EAST OF ENGLAND OFFICE

Re: ExQ 1

Application by Equinor New Energy Limited for an Order Granting Development Consent for the Sheringham Shoal Offshore Wind Farm Extension Project and Dudgeon Offshore Wind Farm Extension Project. Issued on Friday 27th January 2023

Please find below Historic England response to the ExA 1st written questions at Deadline 1

Title:
Figure 14.4 Palaeogeographic Features

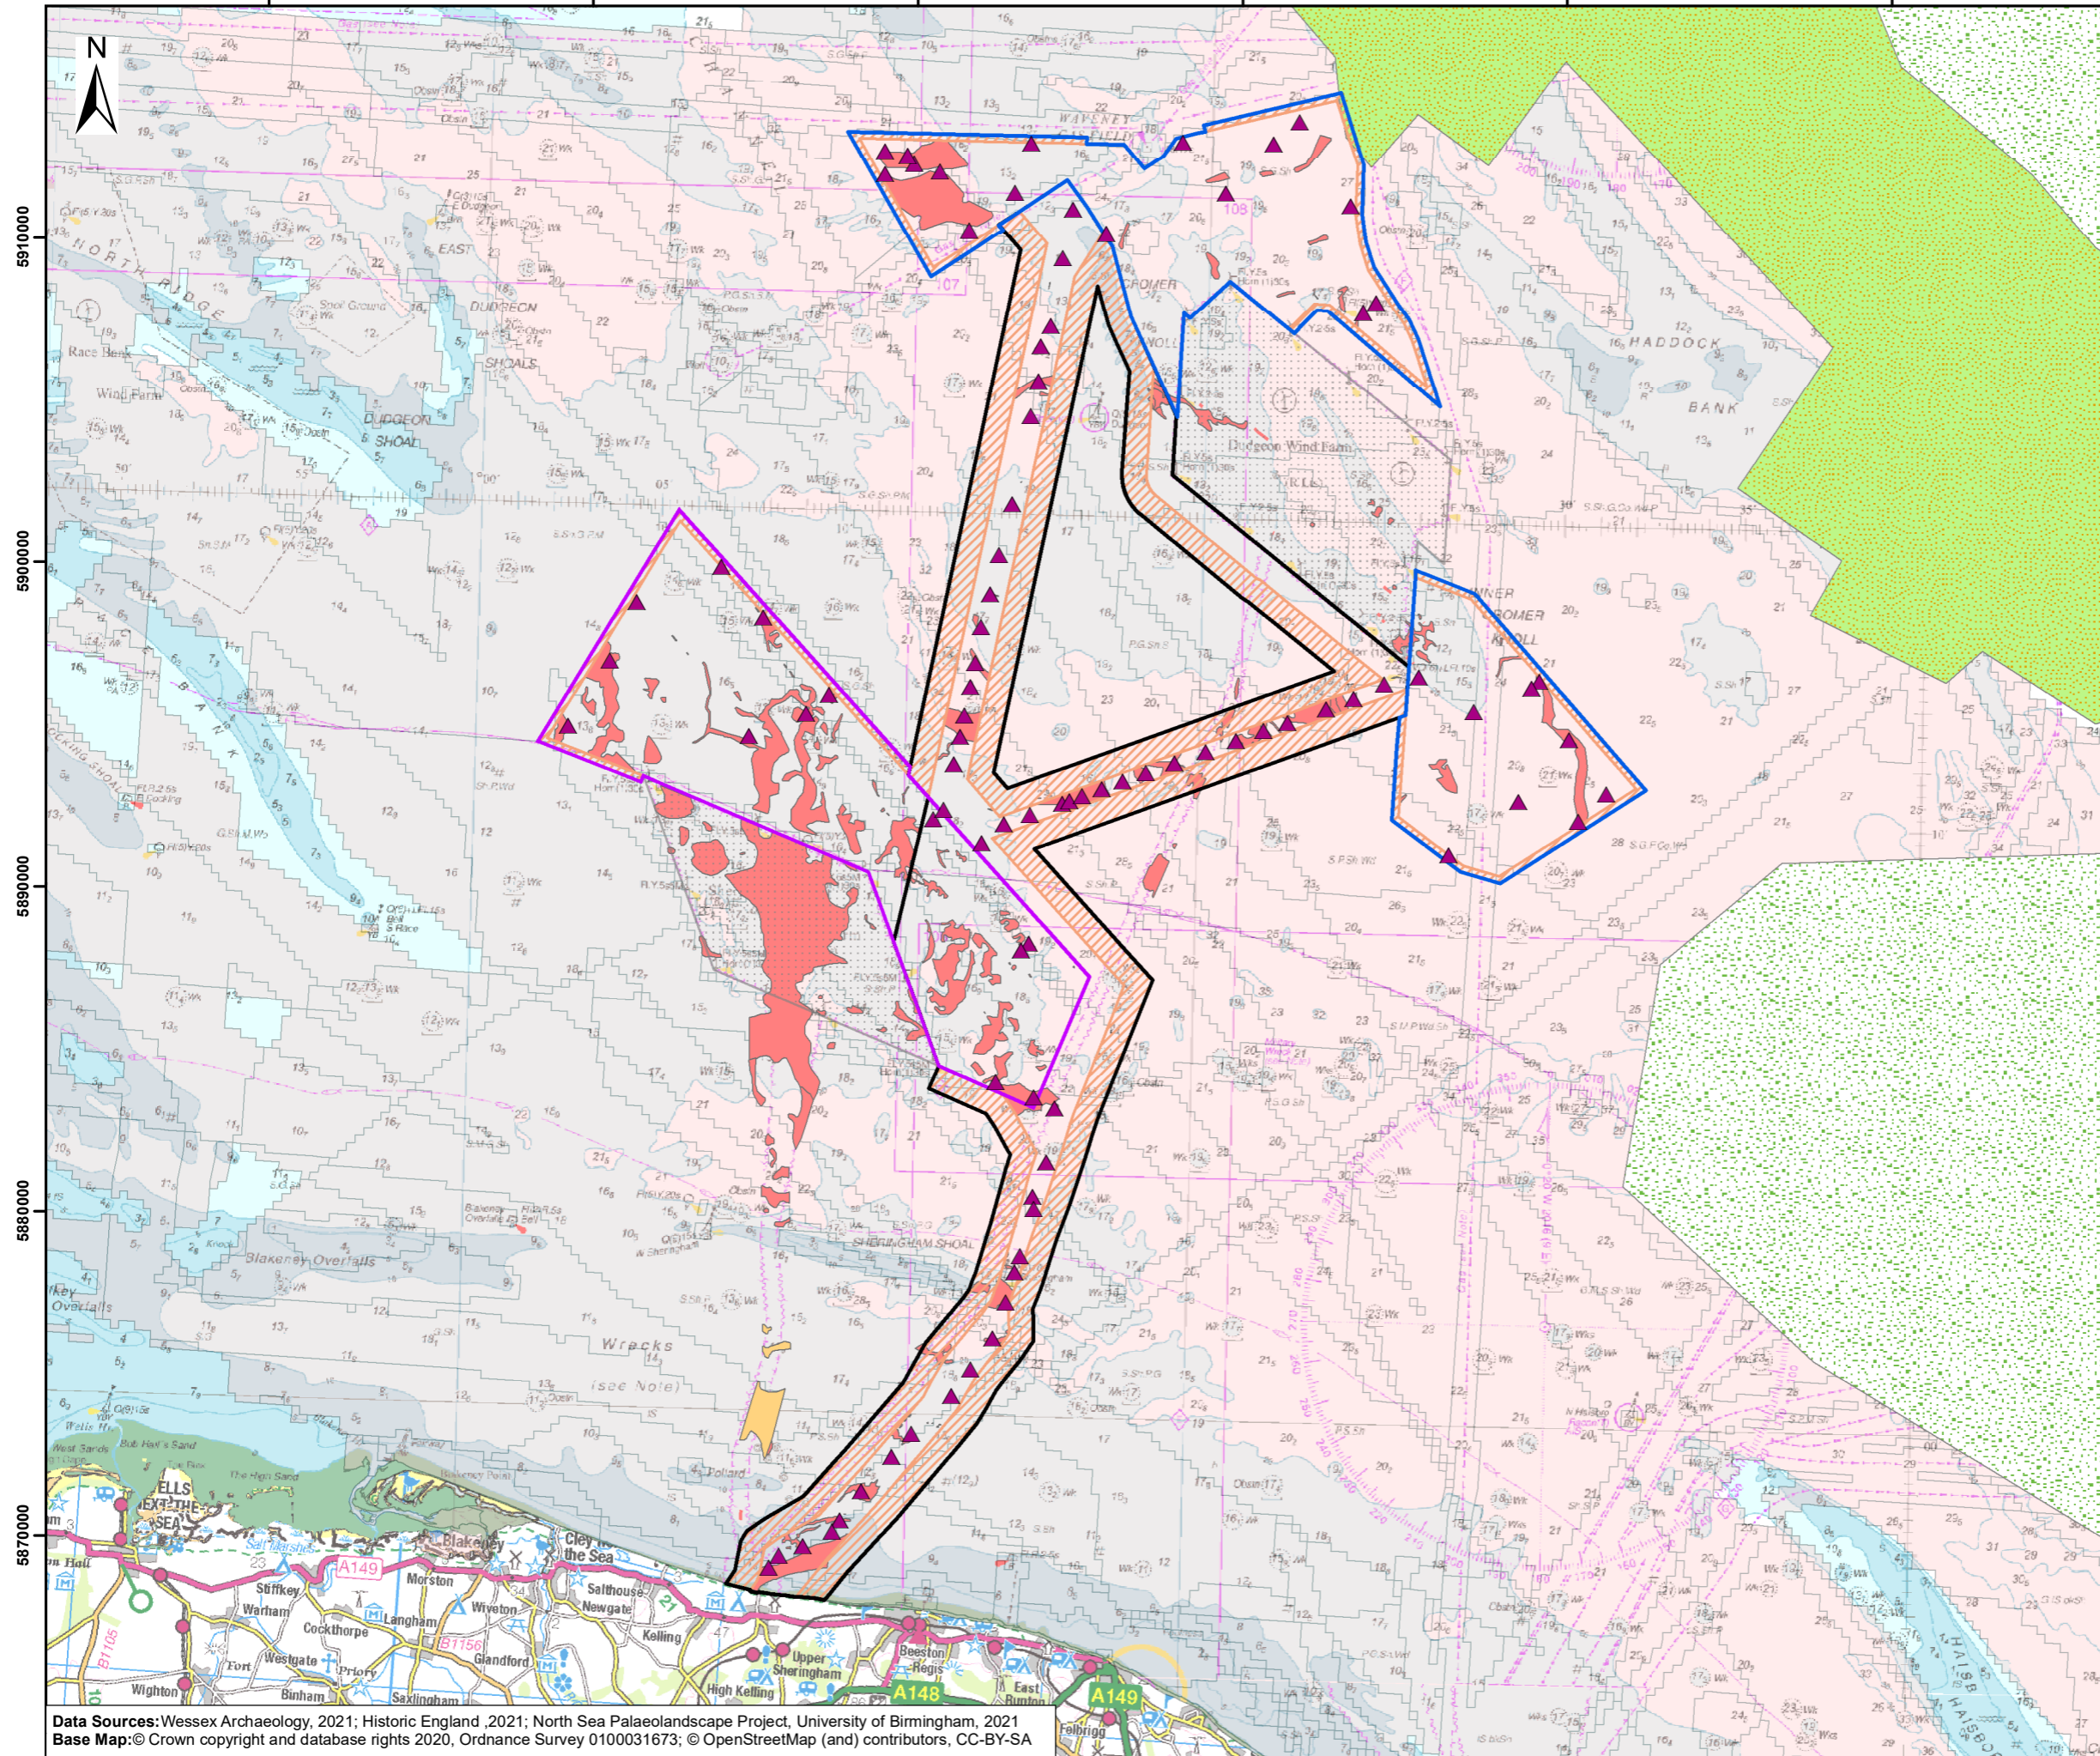
Question Reference	Question	Historic England (HBMCE) response
Offshore matters Q1.15.1.2	<p>AEZs within the Offshore Temporary Works Area</p> <p>Do you consider any modifications are required to the AEZ limits set out in the ES [APP-100, Table 14-27], or that additional AEZs are required around other identified assets?</p>	<p>We are aware that following the Preliminary Environmental Information Report (PEIR) consultation an amendment was made to the proposed Order Limits to include an Offshore Temporary Works Area (i.e. a spatially defined adjacent areas of seabed that may be required for “temporary works” e.g. anchoring or deployment of jack-up vessels.</p> <p>We are aware that there are numerous features of archaeological or historic interest identified through desk-based assessment in the Offshore</p>

<p>Temporary Works area, as plotted in Figure 14.5 in ES Chapter 14 Figures – Offshore Archaeology and Cultural Heritage (PINs Ref: APP-126). Regarding the delivery of mitigation, we note the recommendation that AEZs of 100m are implemented around the 16 UKHO records within the Offshore Temporary Works Area, as measured around the recorded point locations to try and include the full extent of wreckage and associated debris.</p> <p>For the purposes of the ES, however, a review of existing desk-based data, and previous archaeological assessments undertaken for DOW and shows that there are 21 additional wrecks and obstructions (Table 14-20) listed by the UKHO within the Offshore Temporary Works Area. It is also apparent from Table 14-20 that numerous records are described as “dead wreck” such that no wreck has been found in subsequent (UKHO) surveys with the location considered to represent a reported loss only. Therefore, use of a measured point location for these records is accepted.</p> <p>It should be noted that subsequent higher resolution geophysical survey (and any visual inspection)</p>

<p>my reveal if a “dead wreck” is now identifiable or for a charted wreck if a wider debris field now exists which requires the AEZ to be spatially delineated differently i.e. as a polygon. We are also aware that there are two further AEZs within the Offshore Temporary Works Area which correspond to the aircraft remains identified during the ROV investigation for DOW (Table 14-21, ES Chapter 14 and also paragraph 237). Regarding Table 14-27, we agree with the general principle that if a wreck (vessel or aircraft) is identified as being highly dispersed, a precautionary 100m AEZ should be implemented. For any wreck which appears to be more intact, an AEZs of 50m around the definable wreck complex is acceptable. However, for highly fragmentary remains, we note that the AEZ identified for aircraft engines/propeller (ID 70819, 70832 & 70842) is a 30m AEZ buffer. It is important to note that the AEZ buffers incorporated into the updated Order Limits, are exclusively based on desk-based assessment, which includes information generated by the same maritime archaeological consultant employed for the assessment for Dudgeon Offshore Wind Farm, as reported between 2009 and 2014. It is therefore</p>

<p>possible that dynamic seabed conditions could now expose previously buried and unknown archaeological features or other sites of historic interest.</p> <p>Furthermore, we accept that a 50m AEZ buffer could be reduced (or increased) within the Offshore Temporary Works Area subject to completion of additional assessment conducted by a professional, accredited and experienced maritime archaeological consultant/contractor.</p> <p>Regarding the use of AEZs around other identified (heritage) assets, we refer you to our Written Representation (paragraphs 5.12, 5.15 and 5.24-5.25). In particular, we are aware that for anomalies classed as “A2” (“uncertain origin of possible archaeological interest”) AEZs are not recommended at this time, which does mean that all parties carry risk that presently identified “A2” anomalies could be of considerable archaeological interest, which depending on location (i.e. within the English Inshore Marine Planning Area) could merit determination for designation. However, we appreciate the considerable number of “A2” presently identified (518) and that some may be contemporary debris of no historic</p>

<p>environment interest. We therefore accept the strategy adopted by this project to include an Outline Marine Written Scheme of Investigation (PINs Reference: APP-298), which is to be delivered as a Consent condition within the Deemed Marine Licences (PINs Reference: APP-024) as an effective means to ensure all survey work conducted post-consent and crucially, pre-construction is informed by archaeological objectives to qualify and quantify the presence of features, anomalies or other sites of archaeological/historic interest. Such professional assessment is to support the use of a classification system, as described above, and application of appropriate mitigation measures such as <i>in situ</i> avoidance through use of AEZs or structured investigation, excavation, recovery, post excavation conservation, permanent curation and archiving if unavoidable.</p>
<p>Onshore matters Q1.15.2.1</p>	<p>Outline Written Scheme of Investigation Are you satisfied that the OWSI, and its accompaniments, provides sufficient protection for unknown heritage/ archaeological assets with appropriate mitigation in place to preserve such assets?</p>	<p>As set out in our Written Representation we have some concerns that the post-consent investigations proposed in the Outline WSI may not fully identify unknown archaeological heritage assets prior to the construction phase and we recommend that post-consent survey work should be more comprehensive in its</p>
